Date 11 September 2020

**RE: 6/2019/2714/OUTLINE – 1 YMCA, 90 Peartree Lane, Welwyn Garden City, AL7 3UL**

Julia Puton  
SuDS Officer  
Hertfordshire County Council

DRAWING STATUS				
INFORMATION				
SCALE @ A1	DATE	DRAWN BY	CHECKED	
1:250	DEC '20	IL	JJ	
DRG NO.		REVISION		
C190906-PIN-XX-XX-DR-C-0210		P01

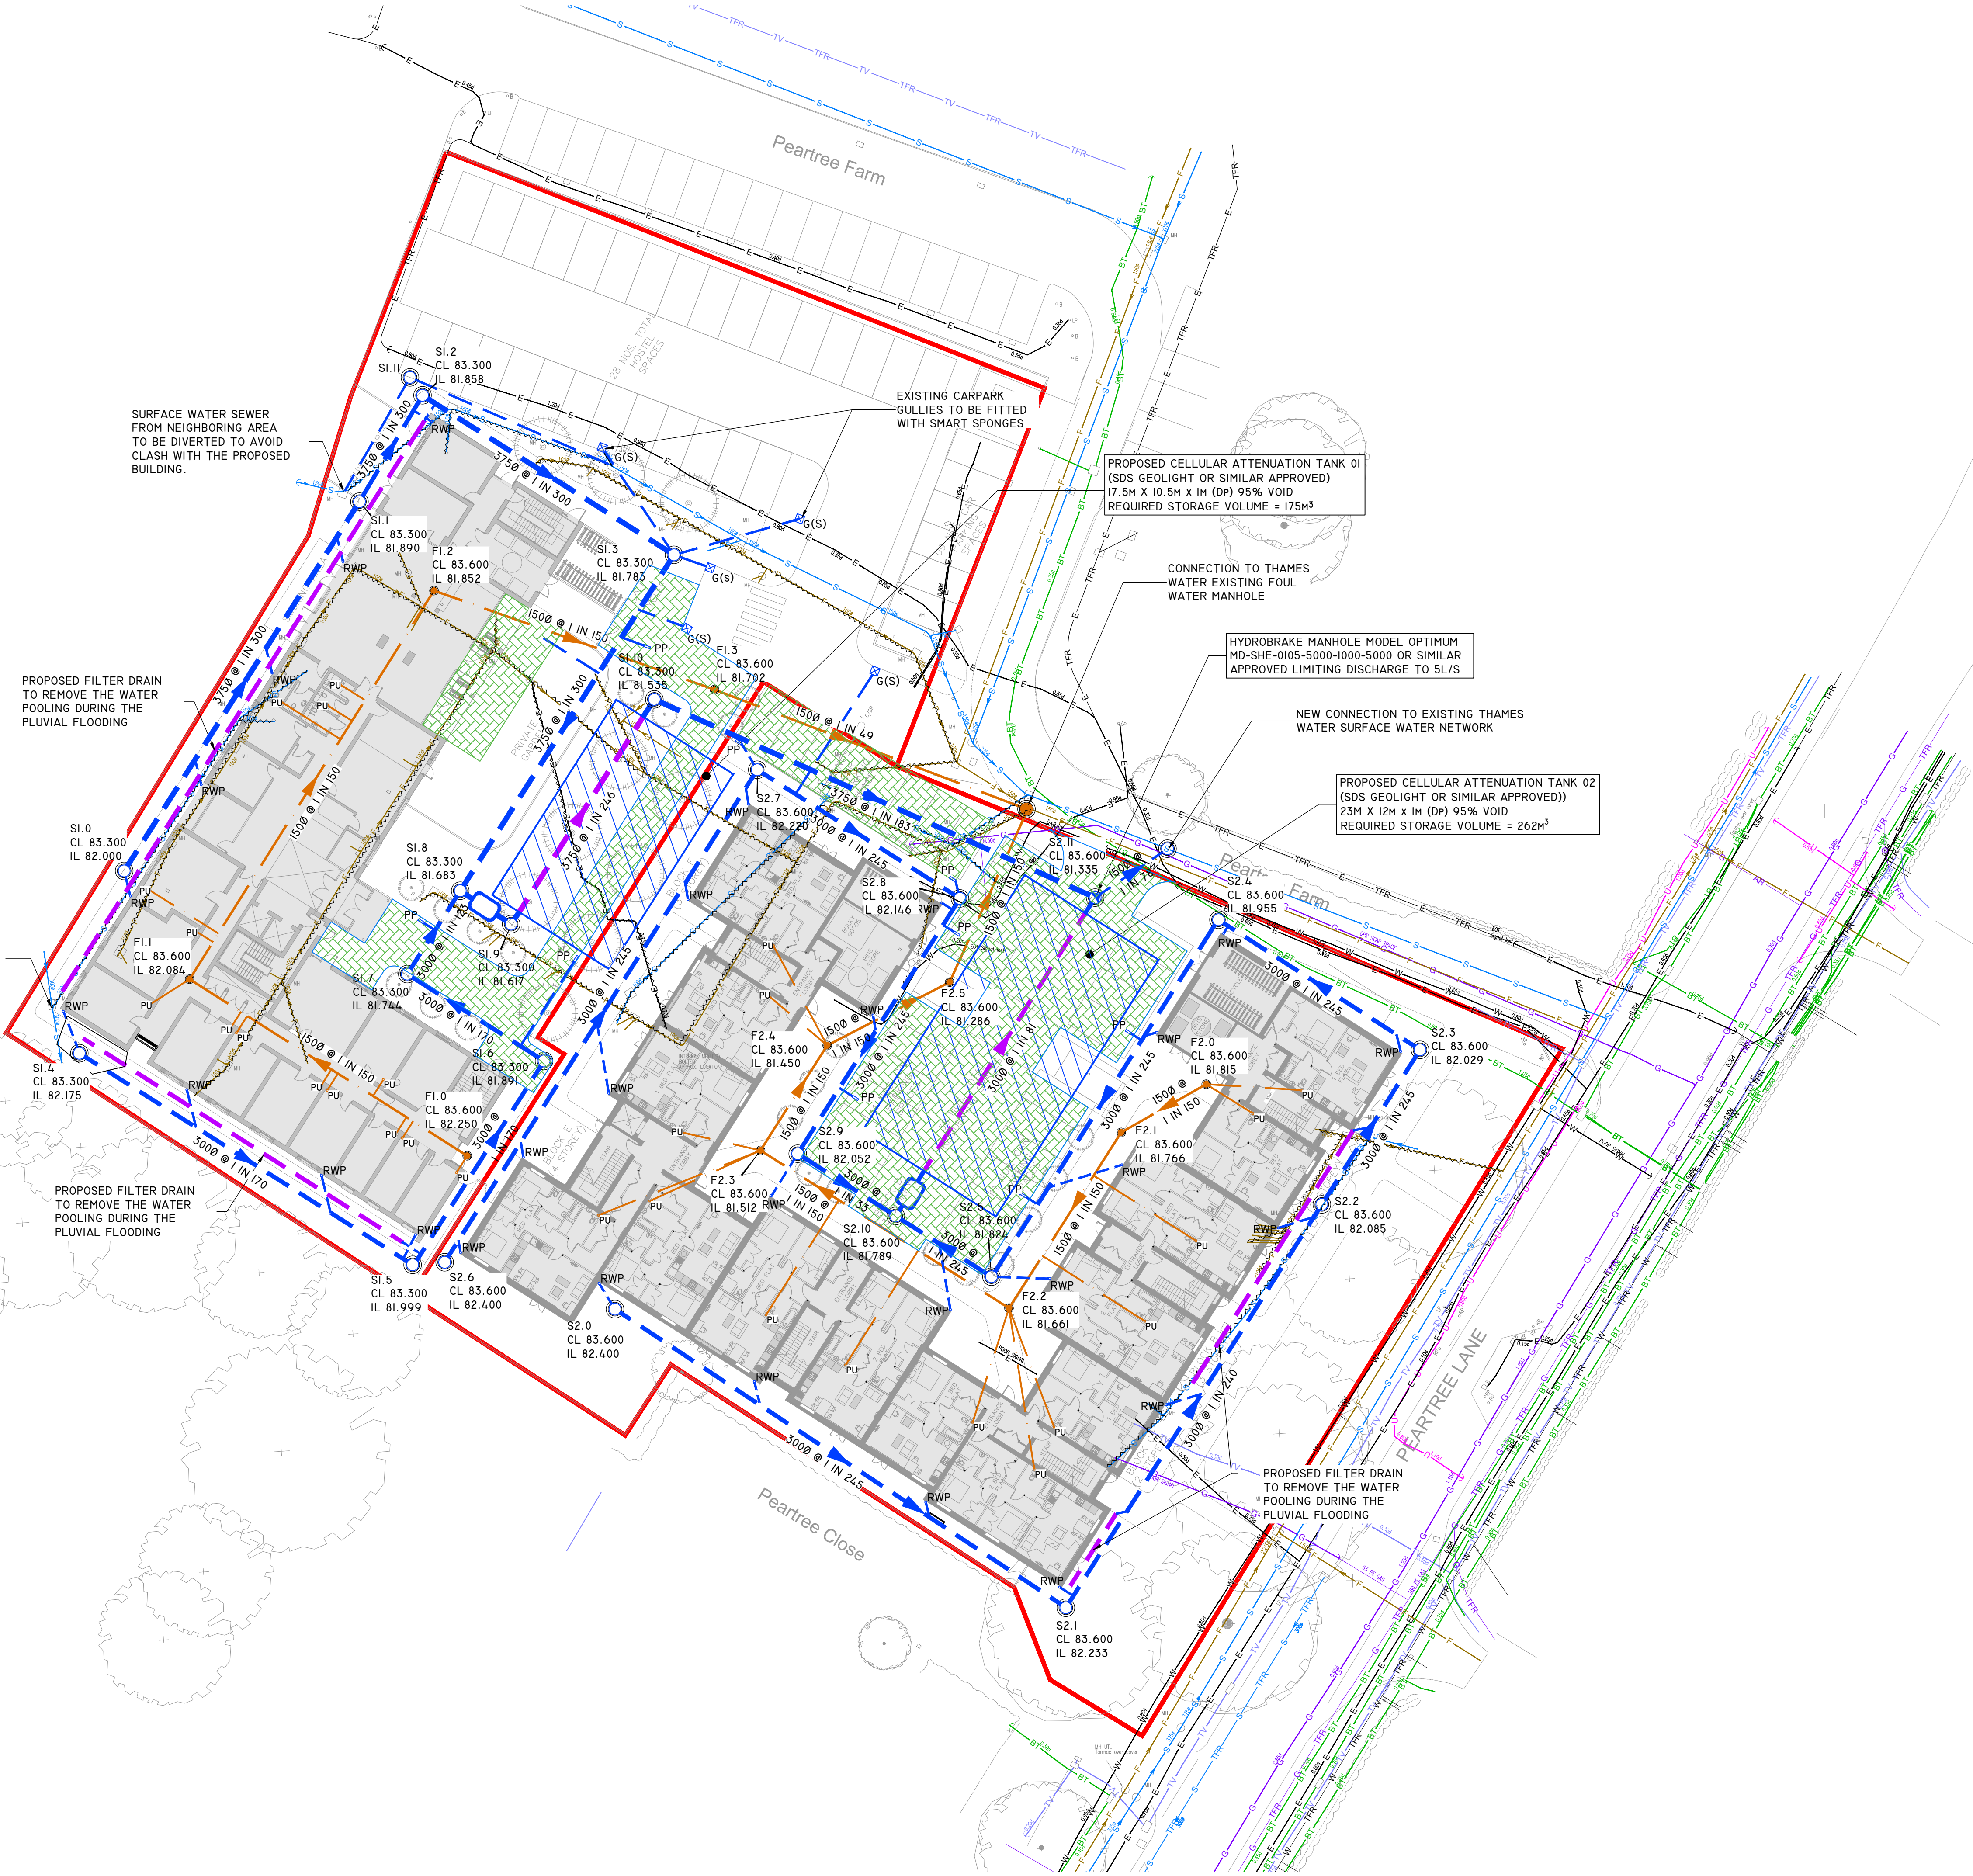
We note Thames Water agreement has been provided. We understand that 5 l/s of discharge has been agreed from catchment B. We would advise that a flow control should be identified on a plan, as unrestricted connection will not be approved.

Moreover, we note that applicant has clarified that the car park will drain via an existing network, which includes two gullies and direct discharge into Thames Water sewer. We understand that the car park may be constrained, however the current proposal is not acceptable. The car park has to be included in the drainage strategy and needs to be appropriately drained. If there is no possibility of a storage structure being proposed within the car park, this area should be connected into the private

Based on the above the applicant needs to provide an updated drainage strategy with a drainage layout including any further updates, indicating the proposed discharge rate and all flow control structures.

Based on the provided drainage layout, we note that both catchments include road gullies connected directly into the private network, with petrol interceptors prior to a discharge into tanks. We would not consider this as an appropriate treatment train and the applicant should consider further treatment allowance.
